Your Ref: OWPC25338
Our Ref: Y/89/19/HH
Please ask for:
Amber Willard

Single storey side extension linking semi-detached garage to existing house including conversion of existing garage to habitable use and rear extension. This application affects the setting of a listed building.

Hazel Cottage Church Lane Yapton

Roof Plan

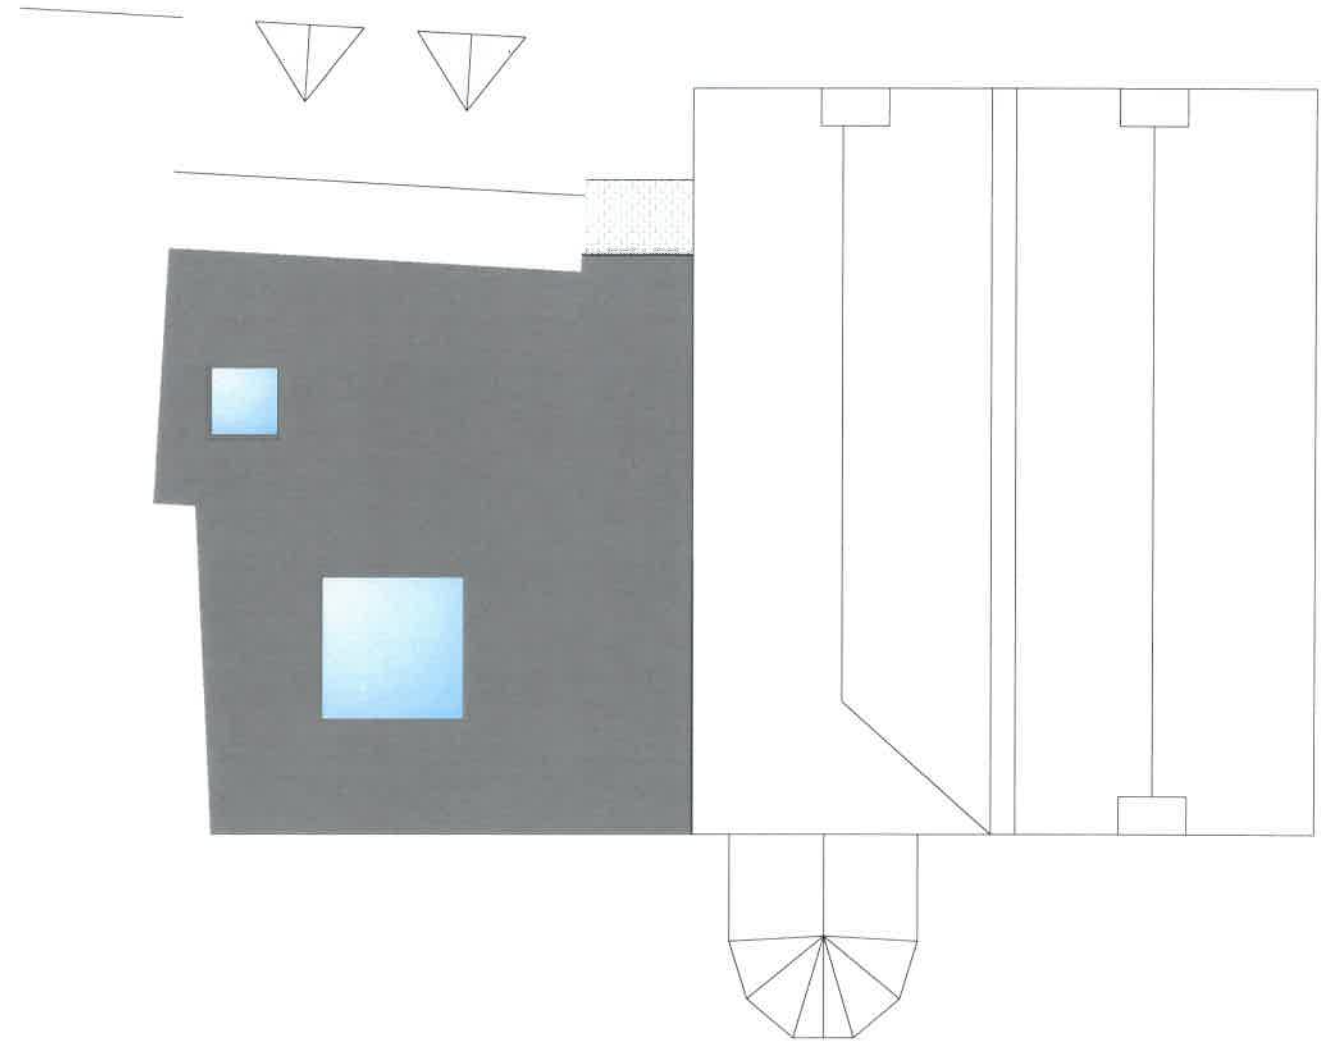
- dormer windows are removed from the new side extension fronting Church Lane. The two proposed windows are incongruous to the historic streetscape of this part of Church Lane.

YPC remain deeply concerned with regard to the impact the proposed two dormer windows will have on the Church Lane streetscape and would prefer the use of conservation style velux windows in place of the proposed dormer windows.
